Consultation Response from: KC Environmental Health (Pollution & Noise Control)		
2026/91093 - 1a, Church Lane, Newsome, Huddersfield, HD4 6JE		
Discharge of details reserved by conditions 1 (noise assessment report), 2 (sound insulation performance) and 3 (waste collection) on previous permission 2025/93098 for prior notification for change of use from commercial/business/service to one dwelling		
Date Responded: Wednesday, 03 June 2026	Responding Officer: HK	Responding Ref: WK/202615102
Thank you for consulting Environmental Health on the above application. Our response relates to conditions 1 (noise assessment report) and 2 (sound insulation performance) on previous permission 2025/93098. Condition 1 states: 1. Before the development is brought into use, a noise assessment report by a suitably competent person shall be submitted to and approved in writing by the Local Planning Authority. The report shall include: a) an assessment of all noise emissions from the proposed development b) details of existing background and predicted future noise levels at the boundary of the nearest noise sensitive premises c) a written scheme of how the occupants of the above-mentioned noise sensit

**2 Ground floor detail**  
1 : 10

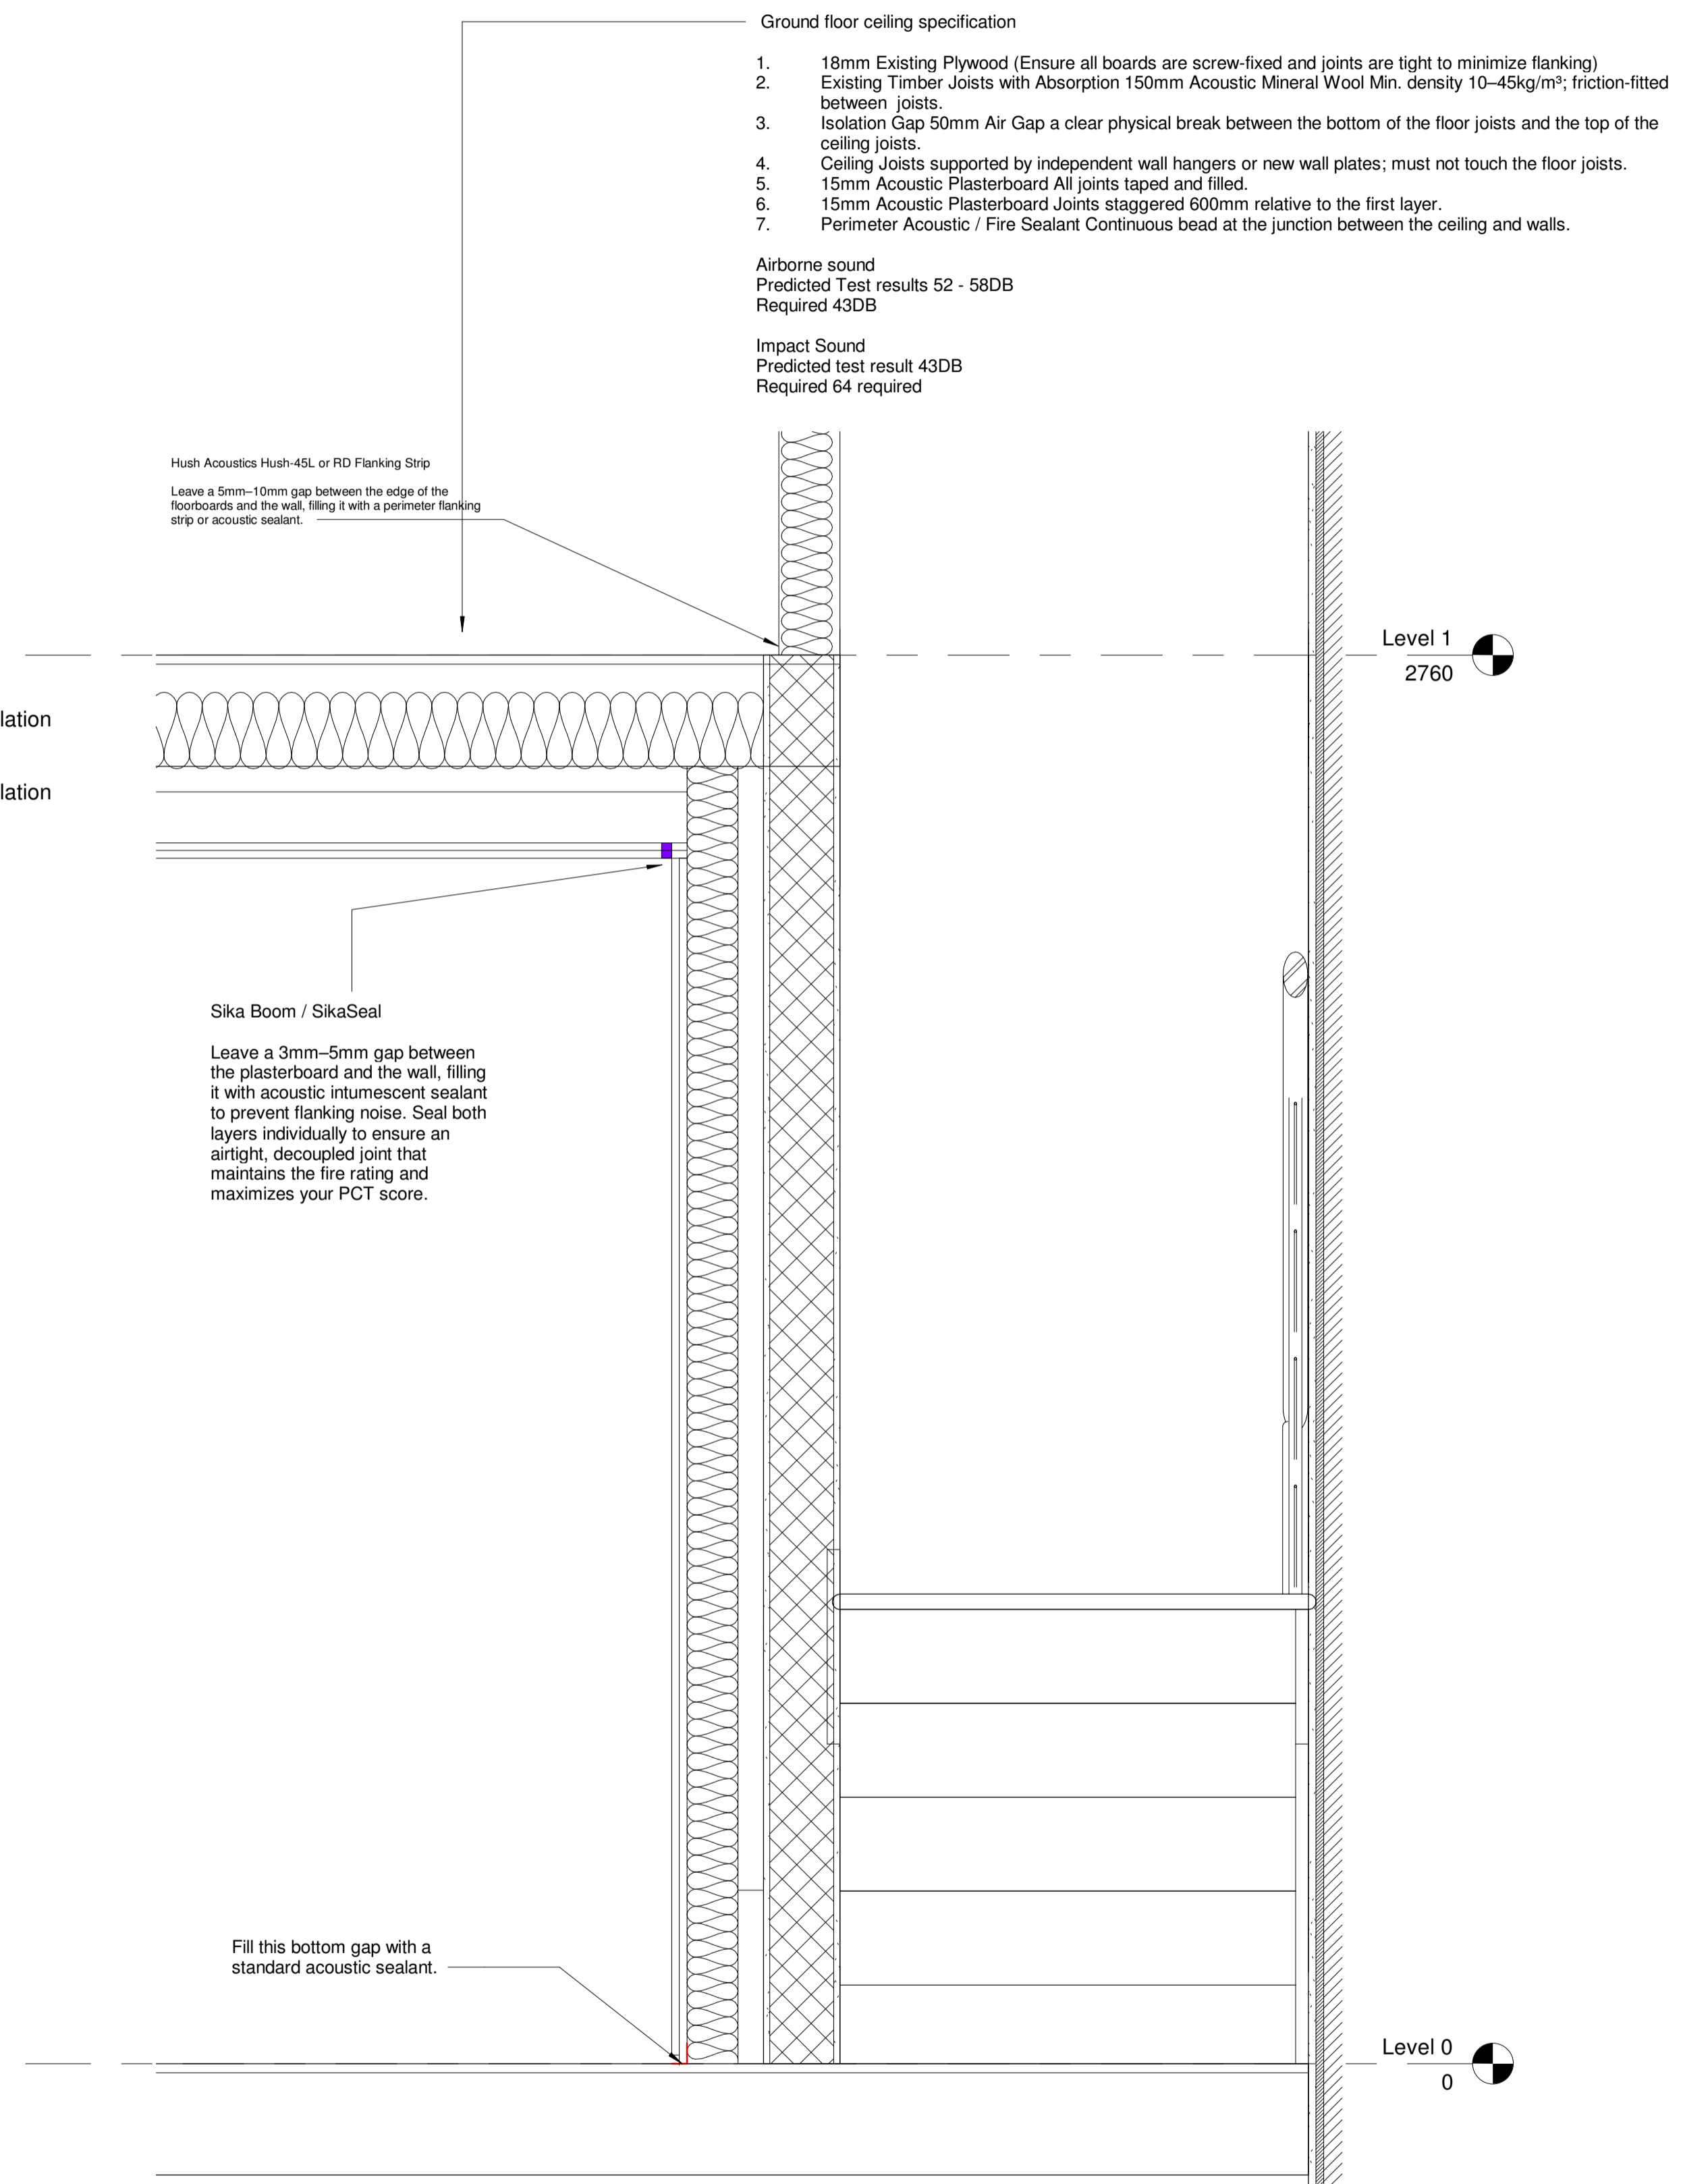
The applicant has submitted a drawing Ref: UD-613, prepared by Unite Designs. The submitted drawing presents details of a build-up specification for the party floors suggesting the following (will achieve the required airborne sound insulation performance specified by condition 2:

The submitted drawing details suggests that the ground floor ceiling specification will achieve the following:

Airborne sound Predicted Test results 52 -58DB Required 43DB

Impact Sound Predicted test result 43DB Required 64

Condition 2 requires that the applicant demonstrates that the sound insulation performance has been achieved – this will require that a sound insulation test is performed once the sound insulation has been installed to demonstrate that the airborne sound insulation achieves a minimum of 53dB DnTw + Ctr. The submitted information does not demonstrate this has been achieved, and therefore condition 2 must remain.

Upon completion of the redevelopment construction work, the applicant should employ a suitably competent person to undertake a sound insulation test. The results of the sound insulation test should be submitted in report format to demonstrate that the party walls/floors/ceilings meet the minimum of 53dB DnTw + Ctr airborne sound insulation performance.

Condition 2 requires the applicant to demonstrate that the airborne sound insulation achieves a minimum of 53dB DnTw + Ctr. The submitted information does not demonstrate this has been achieved, and therefore condition 2 must remain.
